## ***Miontuairiscí / Meeting Minutes***

### ***Ordinary Meeting***

***12<sup>th</sup> June 2023 @ 1.30p.m.***

- 5.5.1 To receive the Chief Executive's Report in accordance with Section 37E(4) of the Planning and Development Acts, in relation to a Strategic Infrastructure Development application made to An Bord Pleanála, reference ABP-316212-23, for proposed development of 26 wind turbines and associated works at the Ballivor Bog Group, County Meath and County Westmeath. (separate attachment)

APPENDIX 4-1

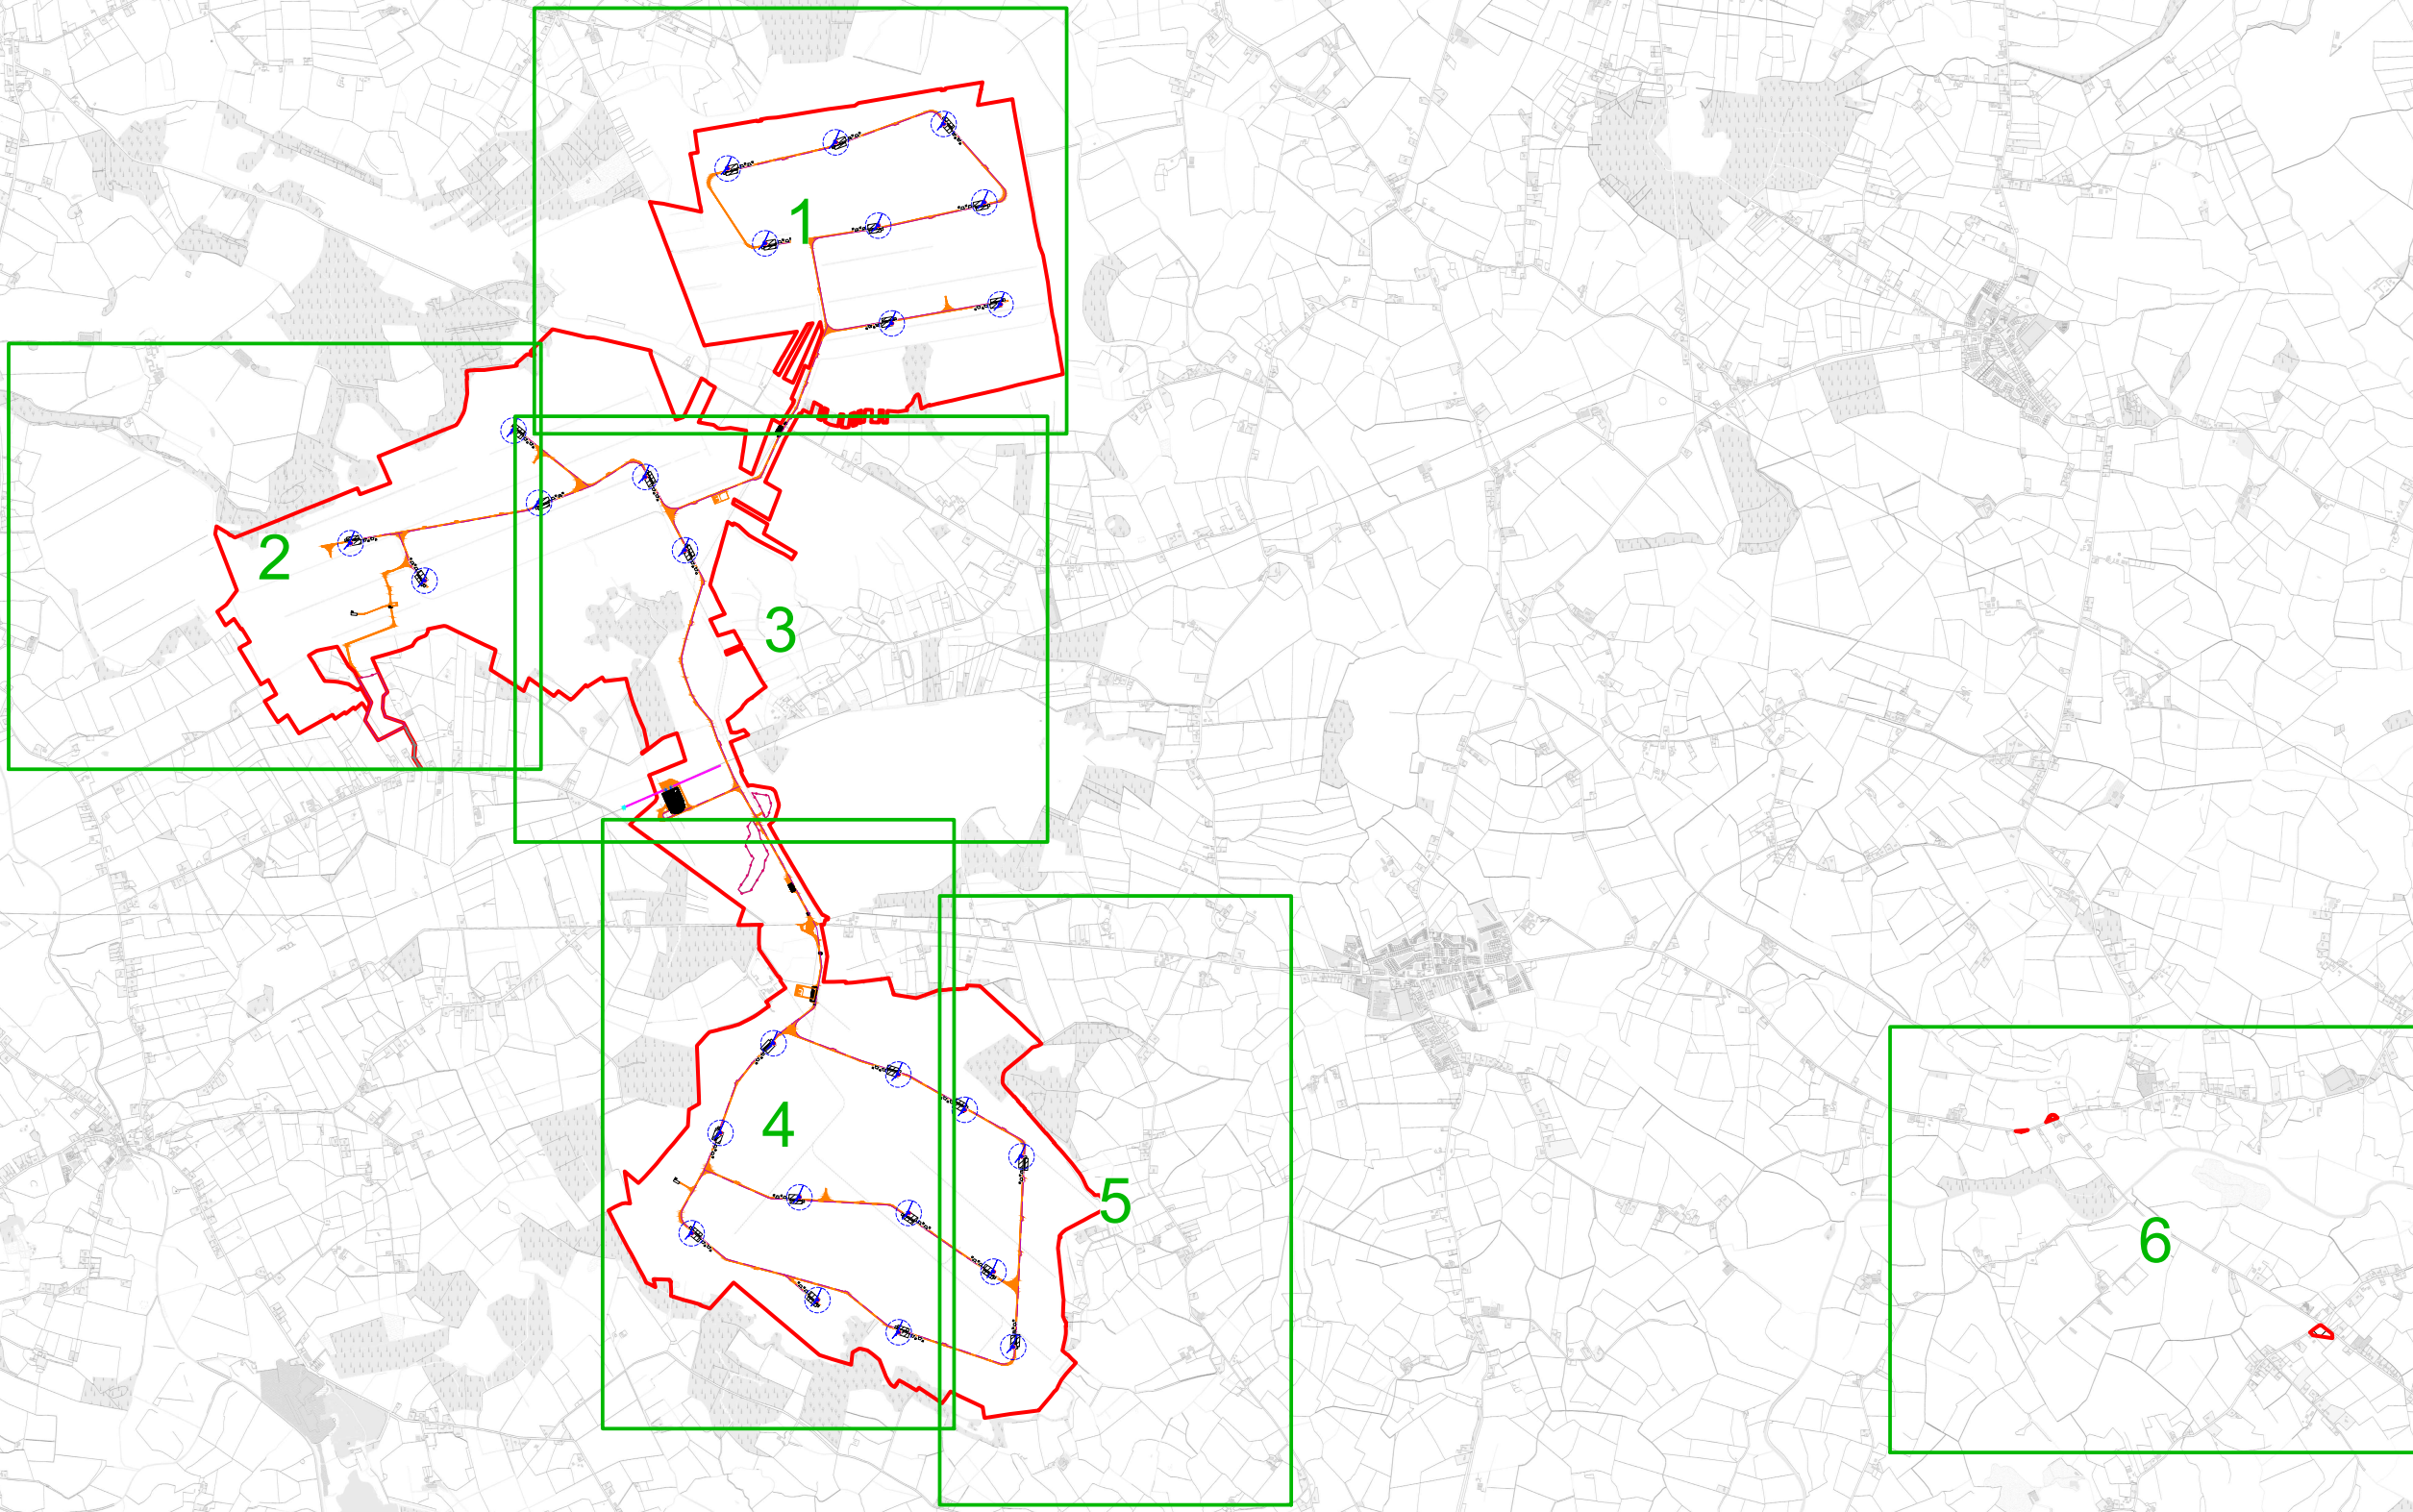
- Lands are/ may be more suitable to a solar farm development.
- Proximity of turbines to residential properties is an issue. Turbines should be located as far away as possible from such properties. Additional lands could be used to provide a greater buffer for residents or assurances that there are no other options (excluding cost).

Most notably, I would like to ensure that BnM have located in particular the 10 turbines in the Meath area as far as possible from residential properties. I would like their full assurances that there are no other options. I do not accept cost as a reason to locate close to housing.

Drawing Title	
Proposed Site Layout	
Project Title	
Proposed Ballivor Wind Farm	
Drawn By	Checked By
DOS	KM
Project No.	Drawing No.
191137	Figure 2-1
Scale	Date
1:40,000	2023-03-01

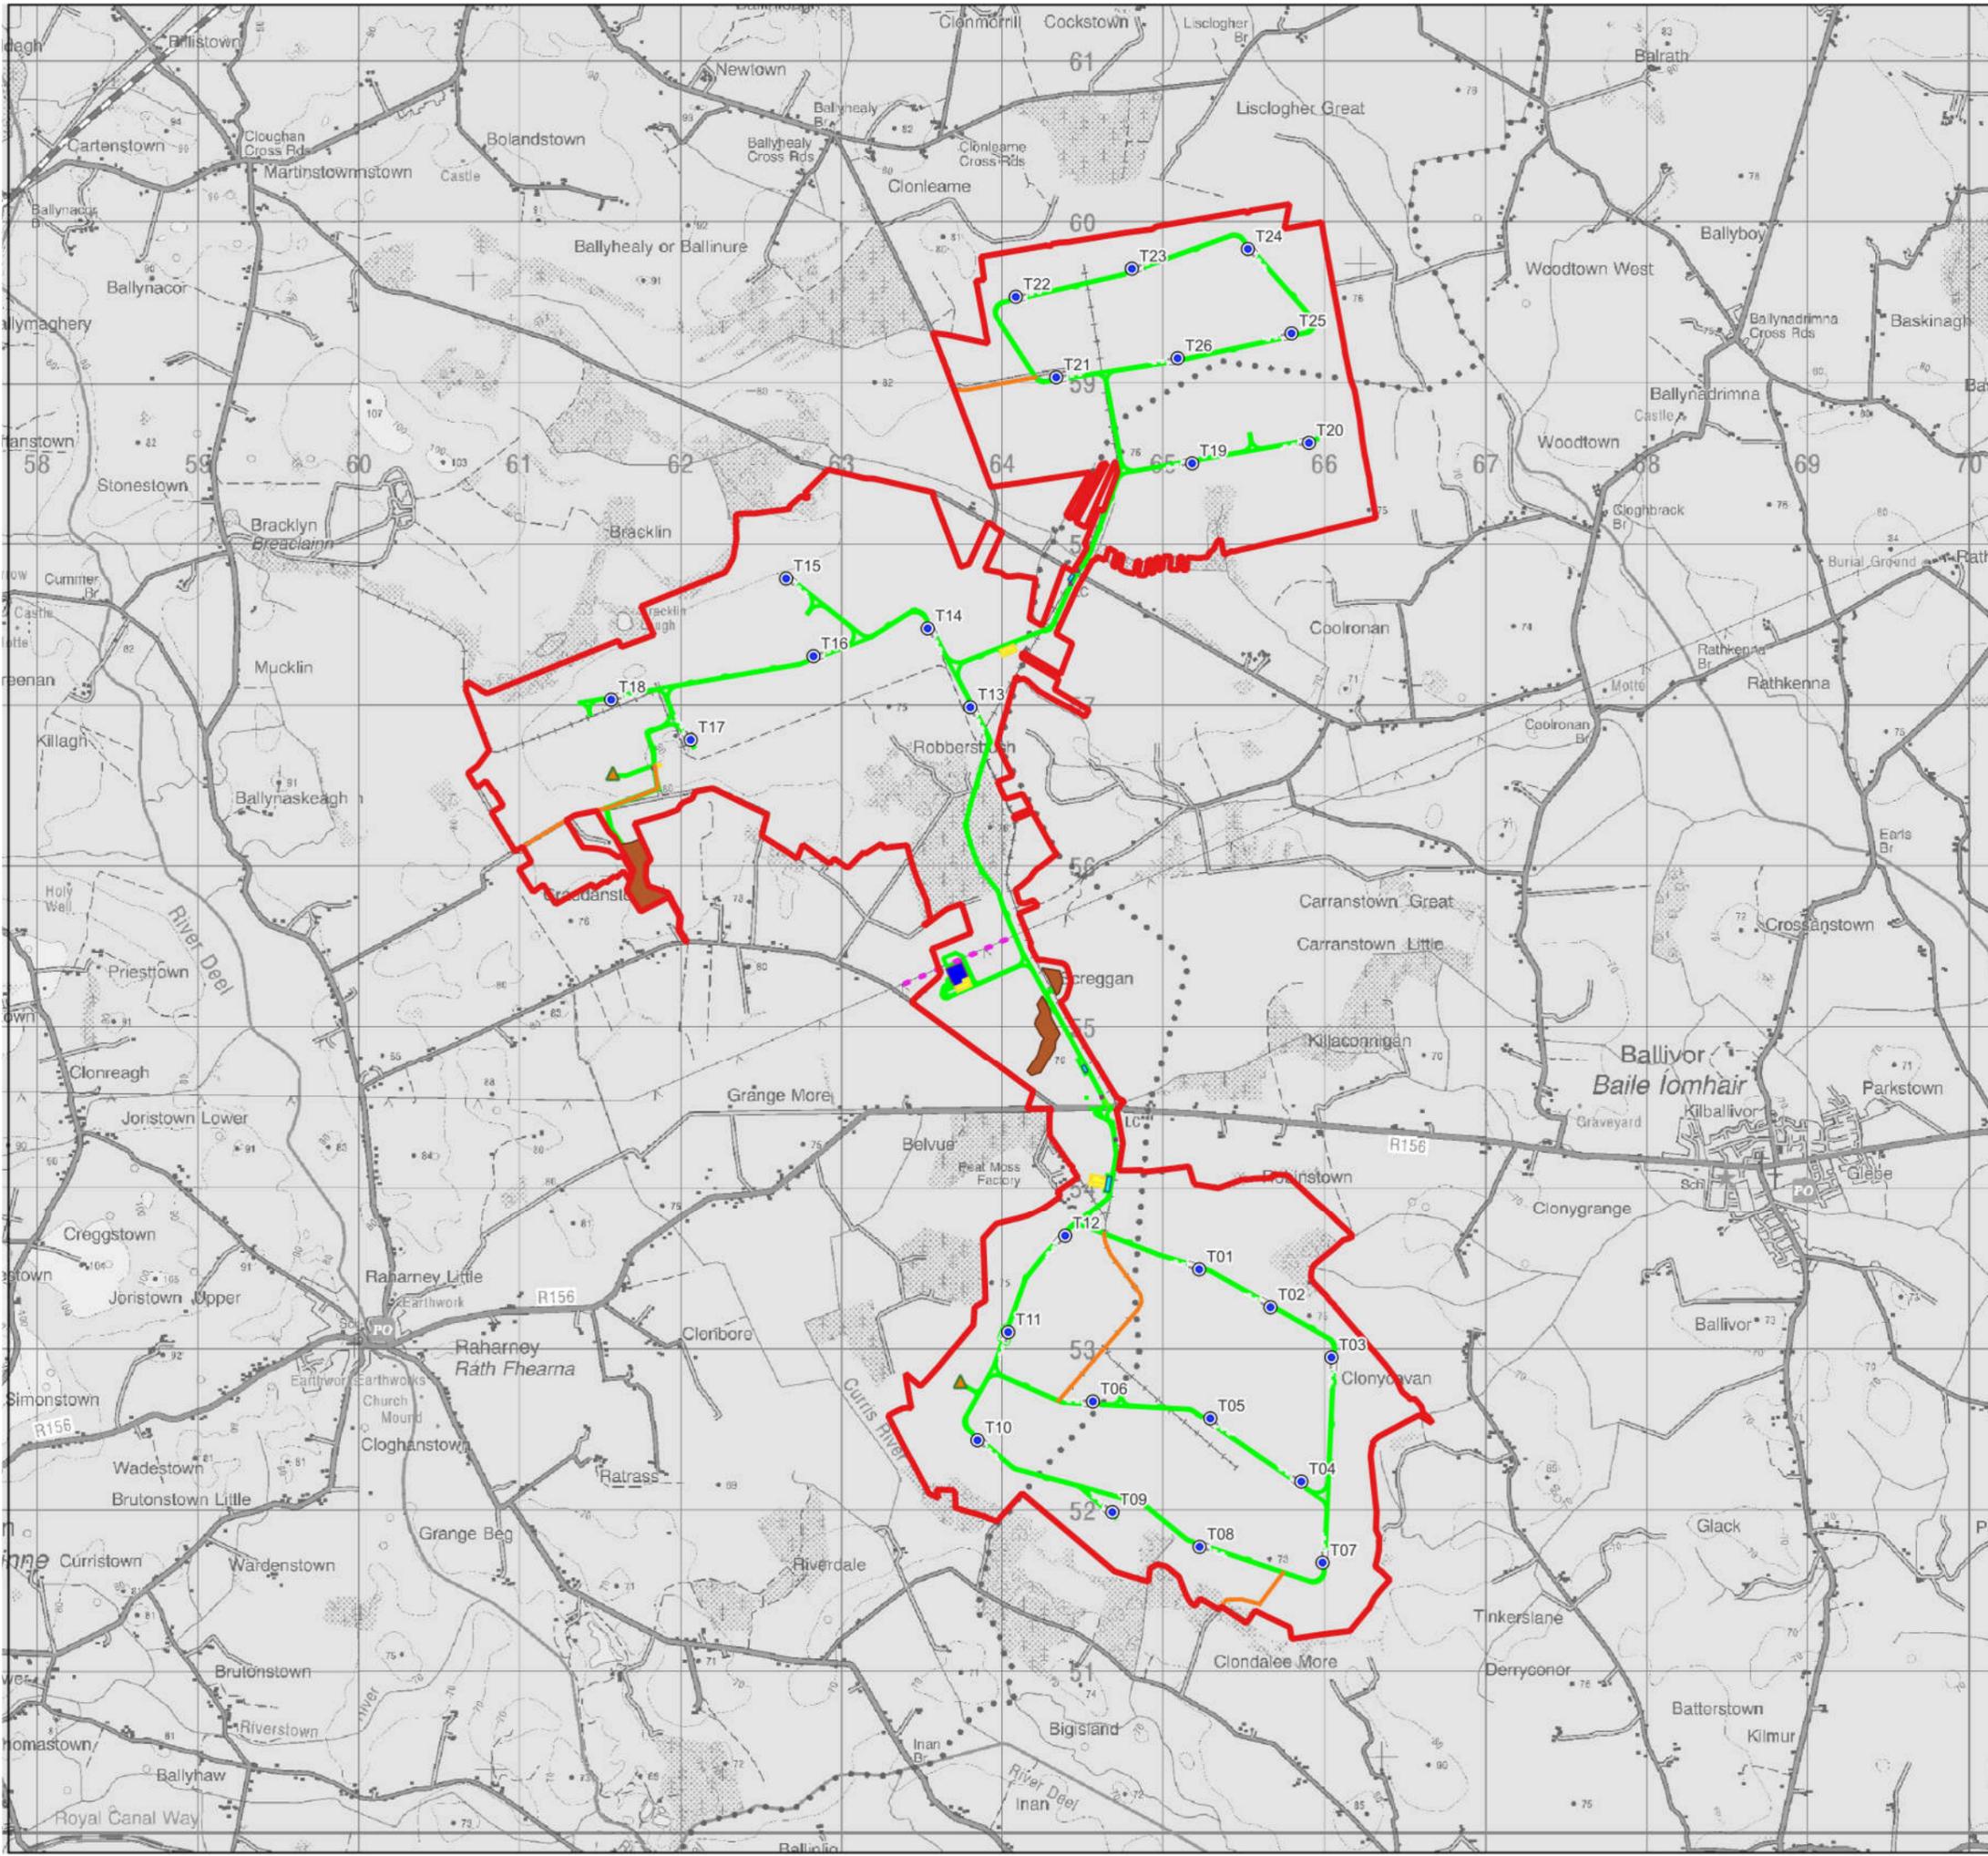
- In addition to proposed paths and cycleways, horse tracks, a natural play park, sensory garden, waymarked posts, orientation information boards and toilets should be provided.

I would like to see more detail around the community benefits/amenities that will be included here. I note the mention of paths and cycleways, what about horse tracks? What about a natural play park and/or sensory garden? Waymarker posts and orientation info boards? Toilets? Many residents are concerned about the cost of their homes being reduced due to proximity to a wind farm. Excellent community amenities may alleviate some of this.
